18 August 2020  
Our Ref: 20728A.10ER\_RTS letter

**RE: SSD-10379  
Redevelopment of Sutherland Entertainment Centre and Peace Park**

DFP Planning has been commissioned by Sutherland Shire Council to prepare a response to the issues raised in the public and authority submissions following the notification of SSD 10379 for the proposed redevelopment of Sutherland Entertainment Centre and the adjoining Peace Park.

ANNEXURE A: MOTORCYCLE PARKING LOCATION
(Sheet 1 of 1)

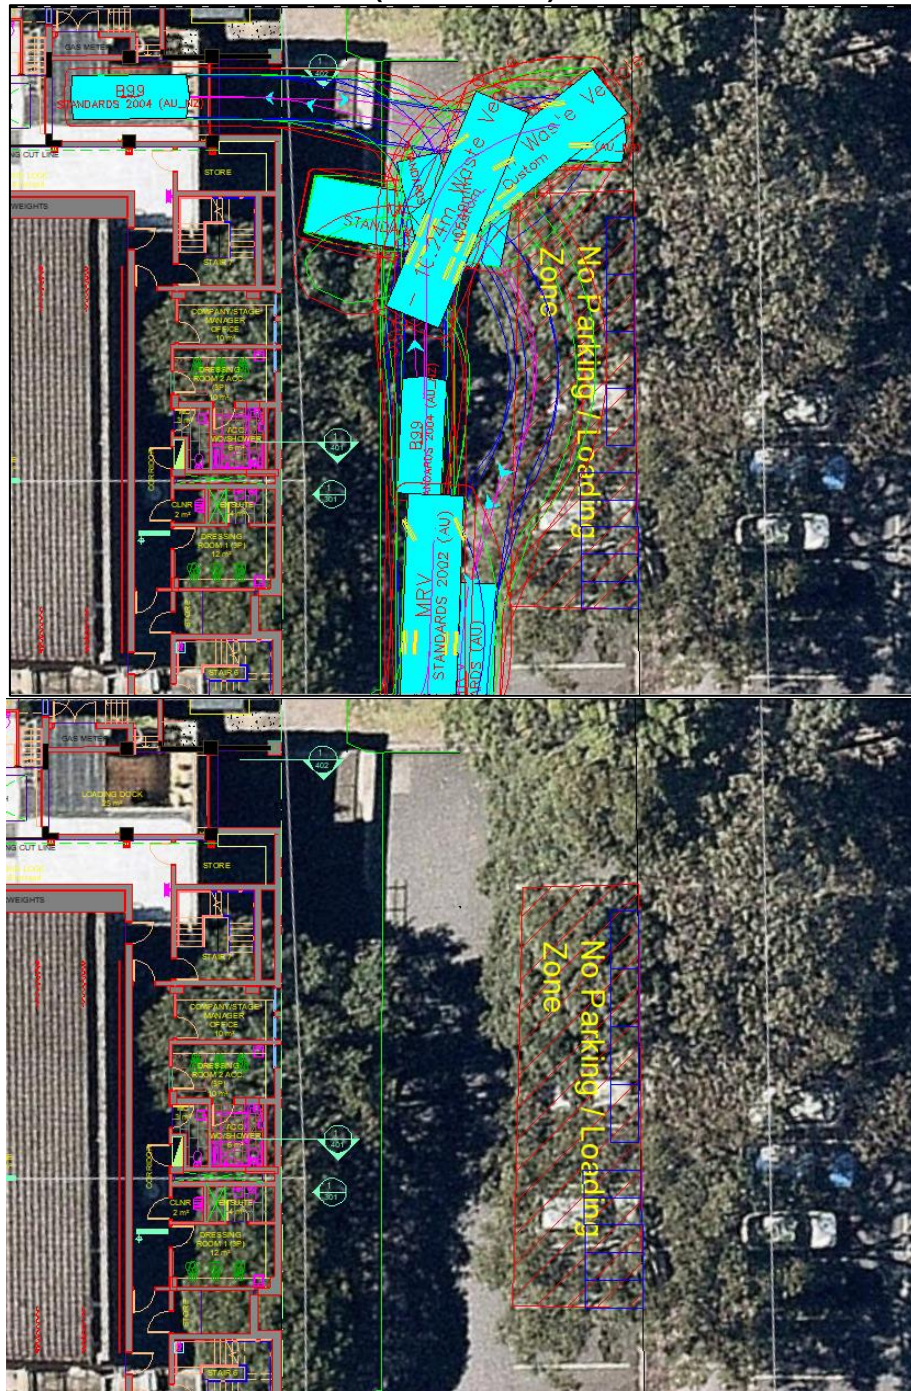
TfNSW has requested that the proponent be requested to address the requirements of Sutherland Shire Council DCP 2015 regarding motorcycle parking, off-street bicycle parking and end of trip facilities.

If the development is approved, TfNSW has suggested that, prior to the issue of the first Construction Certificate, the applicant be conditioned to provide motorcycle parking, off-street bicycle parking spaces and end of trip facilities in line with the Sutherland Shire Council Development Control Plan, 2015 and in accordance with AS2890.3.

There is no feasible location to provide these spaces on site. As an alternative, MTE has recommended that nine (9) motorcycle parking spaces could be provided on Merton Street where parking is proposed to be removed to facilitate waste collection and access for emergency services. MTE has included a mark-up showing the location of these 9 spaces whilst still maintaining access for emergency services and waste collection vehicles – refer **Attachment 2**. The provision of these spaces has been endorsed by Council's Traffic Engineer and would be subject to the approval of the Sutherland Local Traffic Committee.

- b) Prior to the issue of the Construction Certificate relating to works in Merton Street, a plan showing the provision of nine (9) motor cycle parking spaces within Merton Street is to be provided.

The plan must demonstrate that access for emergency vehicles and waste service vehicles will not be impeded by the proposed motor cycle parking.

(Sheet 1 of 2)

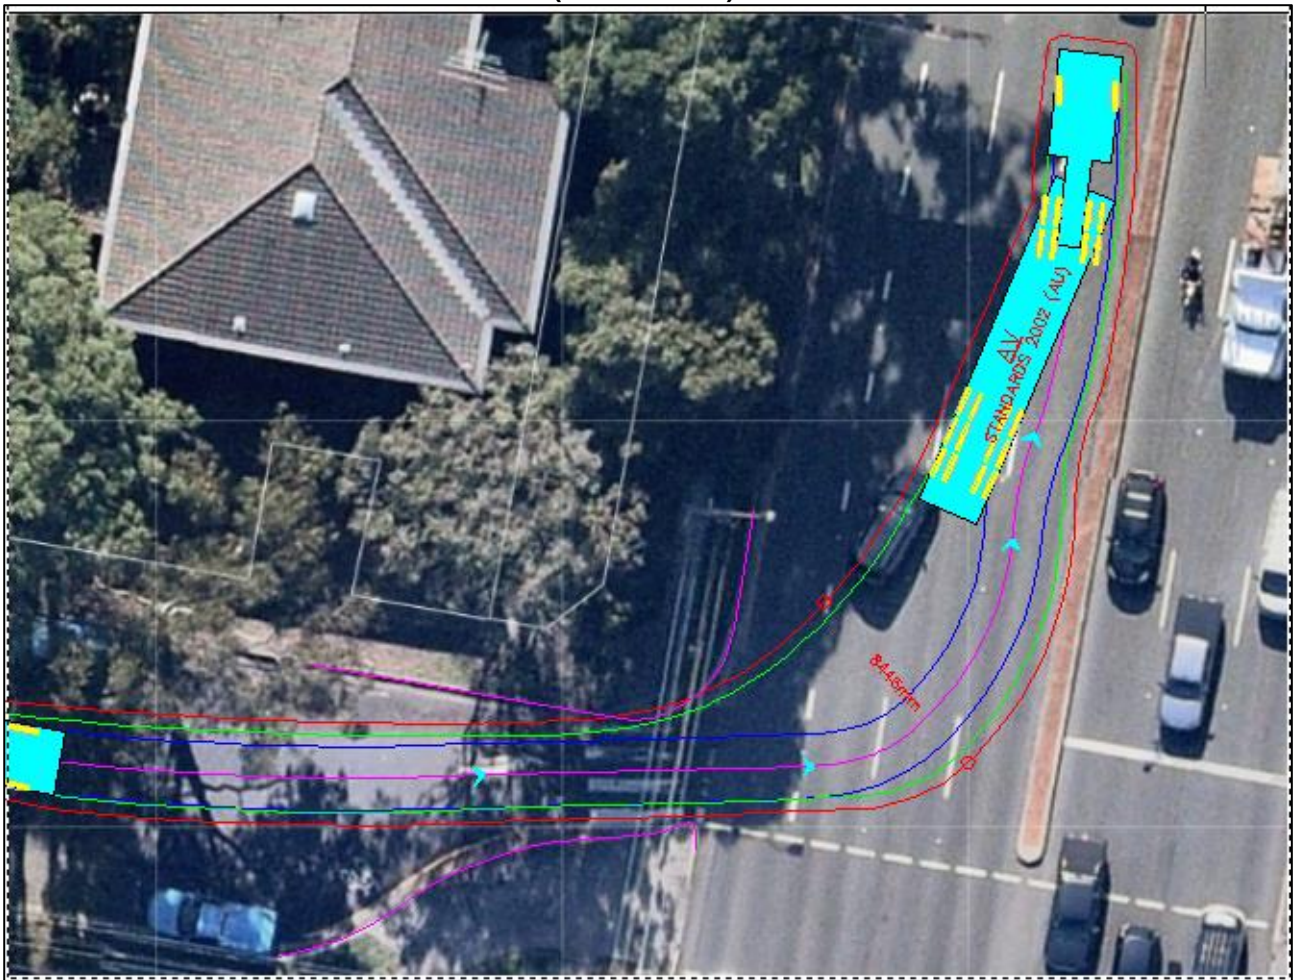
TfNSW has requested that, prior to the issue of the first Construction Certificate, swept path design plans of the longest vehicle (including garbage trucks, building maintenance vehicles and removalists) entering and exiting the subject site, be provided to Council for approval.

MTE has prepared swept path plans for a 19m length Articulated Vehicle (being the longest vehicle likely to service the site) turning at the intersection of Acacia Road and President Avenue and Flora Street onto Acacia Road. These plans are provided at Annexure B of the supplementary traffic and parking response at **Attachment 2**. These paths demonstrate that the vehicles do not travel onto the kerb and medians.
